Date: 1 September 2025

SEA LINK DCO APPLICATION (EN020026)

**SCC PRINCIPAL AREAS OF DISAGREEMENT SUMMARY STATEMENT
(PADSS)**

Document Title: APPENDIX B CONSENTED SPR OUTLINE LANDSCAPE MITIGATION OVERLAIN WITH THE SEA LINK OUTLINE LANDSCAPE MITIGATION FOR NGET SUBSTATION (SCENARIO 2)

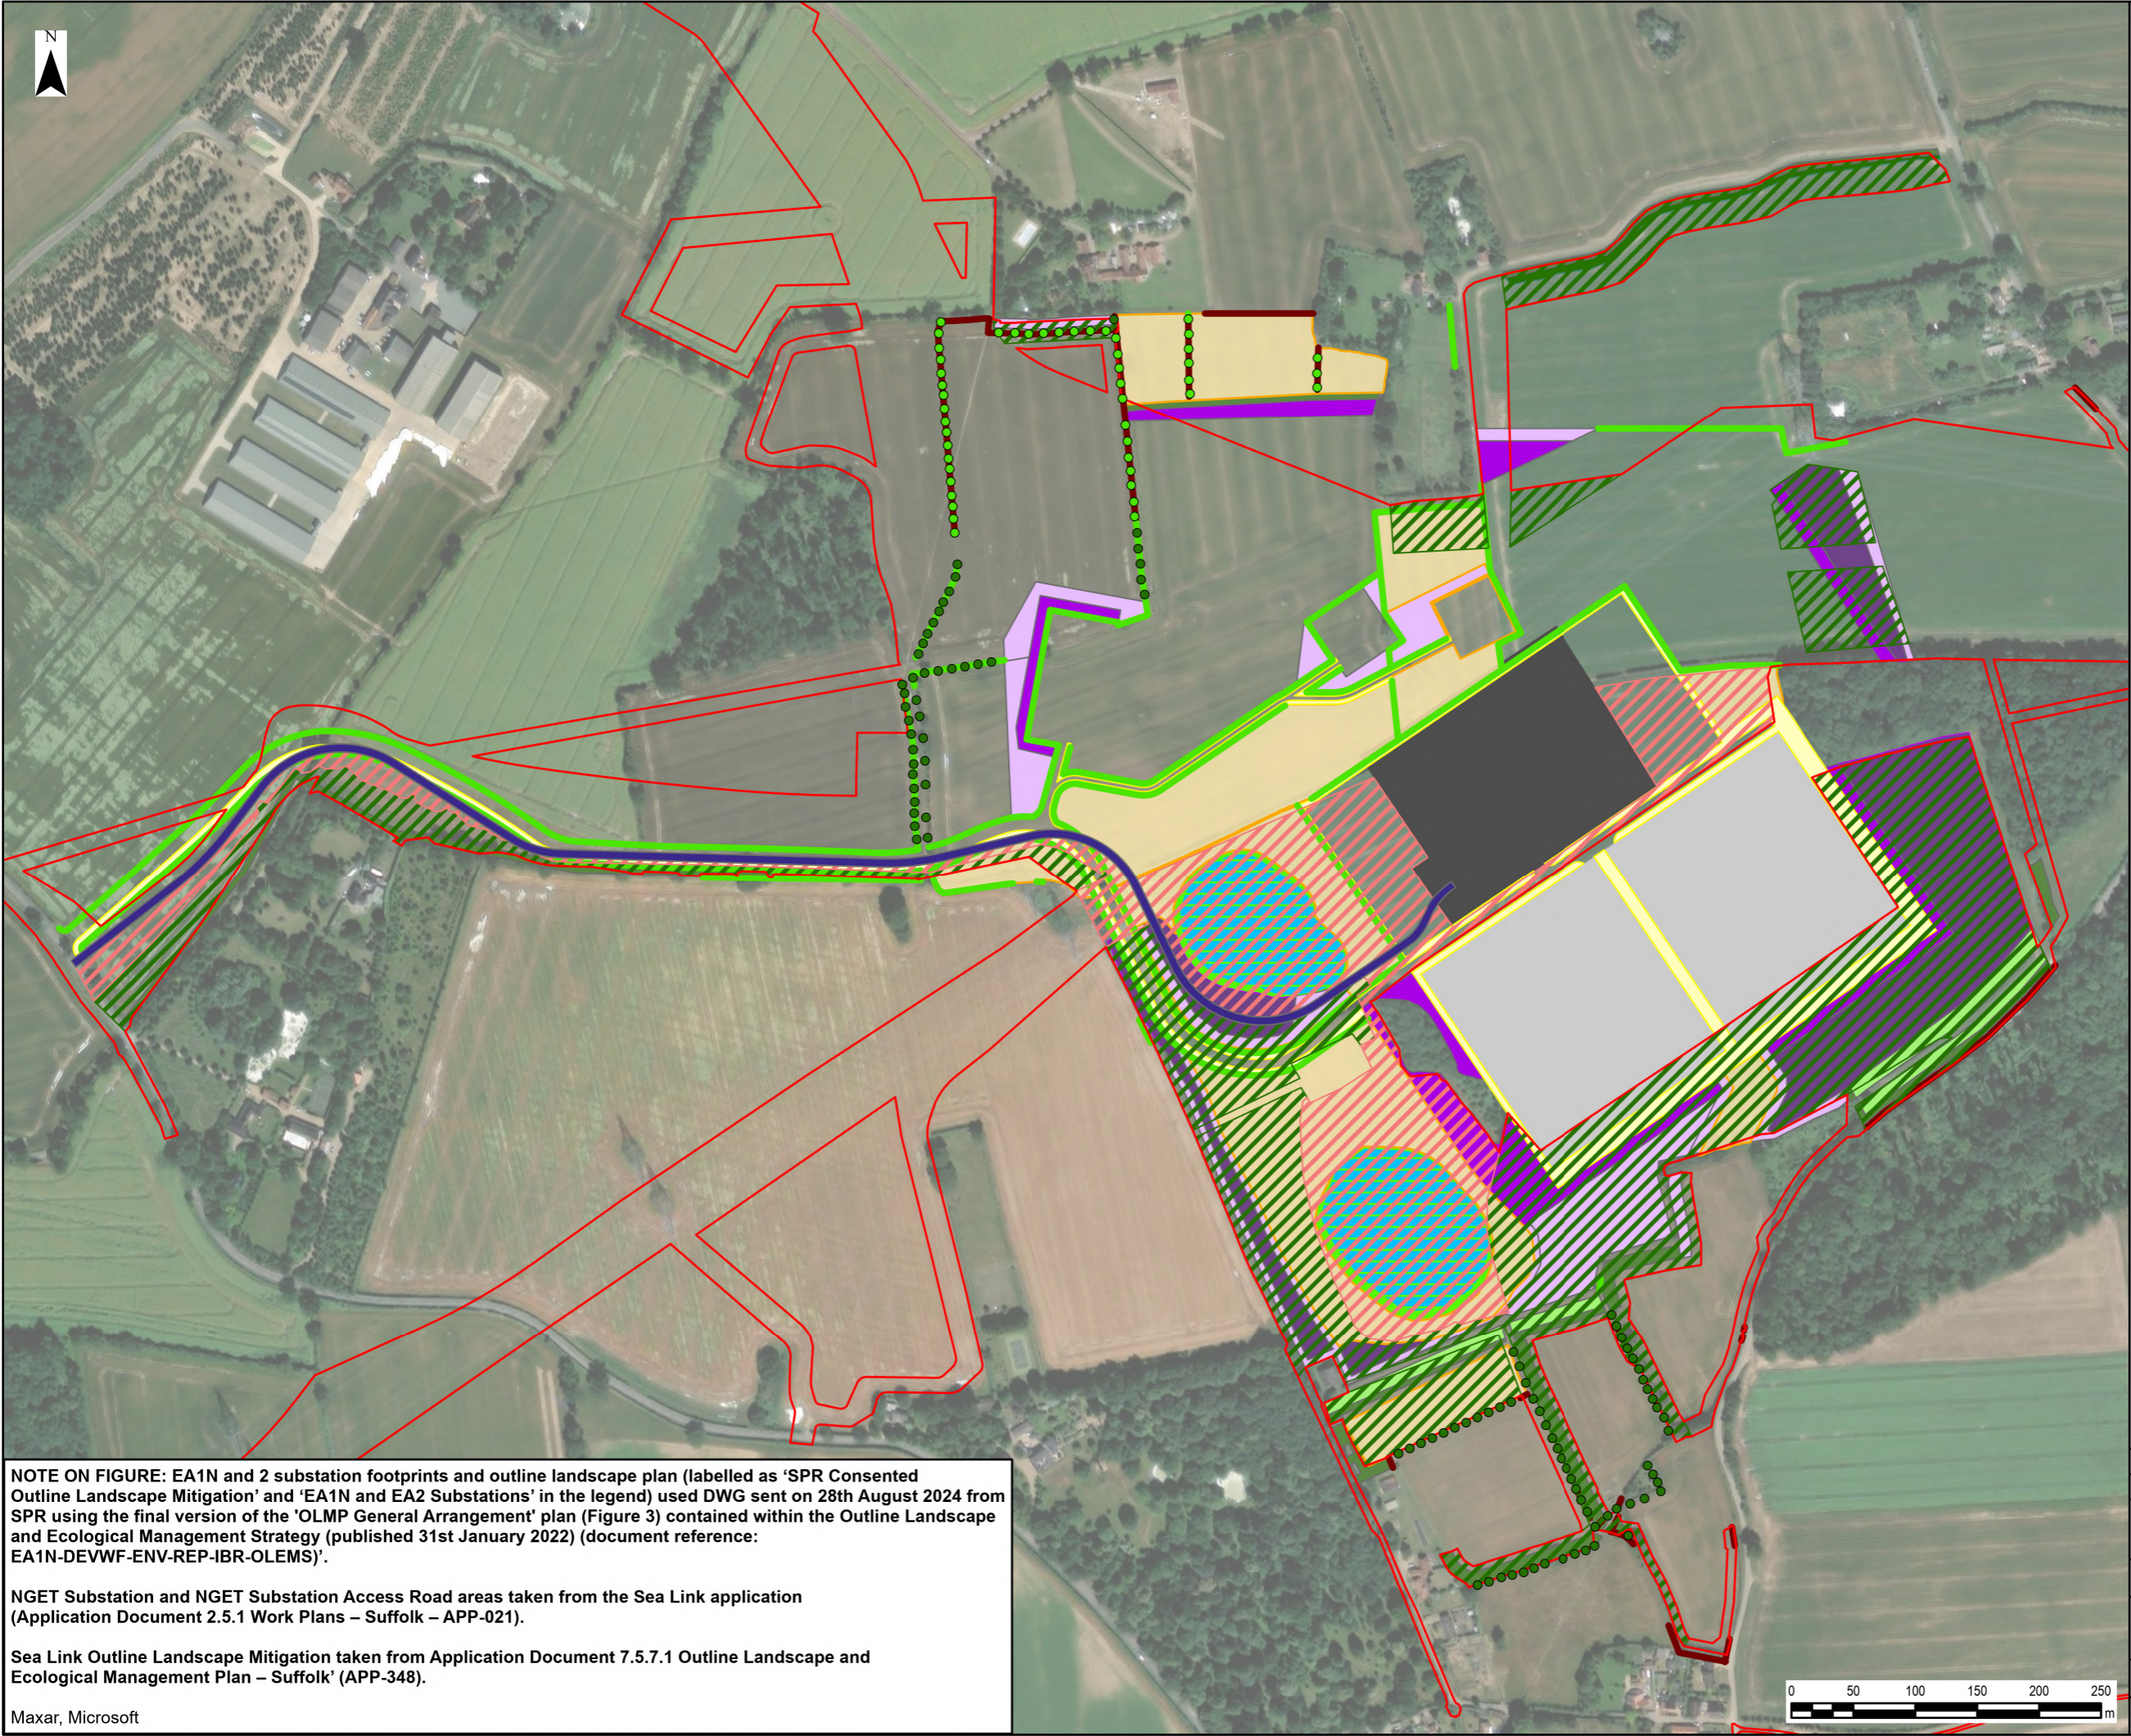
3.2	Friston substation site – Differences between Sea Link and SPR proposals	The Applicant Order Limits regarding the Friston Substation site do not match those consented by Scottish Power Renewables (SPR). Areas of land set aside for landscape mitigation and diversion of public rights of way have not been included.	The Applicant needs to provide evidence that the Order Limits proposed around Friston substation is appropriate to accommodate mitigation for Sea Link, considering the mitigations already secured by the SPR consents.	Not known at this stage.

5.2	Flood risk mitigation	The Council as LLFA is concerned that the current order limits does not appear to provide sufficient space for drainage and mitigation, when compared to what has been secured in the SPR DCO consent for construction of the substation.	The LLFA has produced a Surface Water Management Plan (SWMP) for the Friston catchment, which the Applicant must refer to when assessing the existing surface water flood risk in the area.	Not known at this stage.

7.3	Delivery of substation at Friston – Interaction of cable route with consented East Anglia One North and Two Planting	As currently designed, there is a considerable risk that the HVAC cable corridor route proposed to the substation at Friston could impact the landscape planting consented under East Anglia One North and Two.	The Applicant needs to work with SPR to consider options to minimise the potential impacts of the proposed cable route into the Friston substation on the consented landscape planting for East Anglia One North and Two.	Not known at this stage
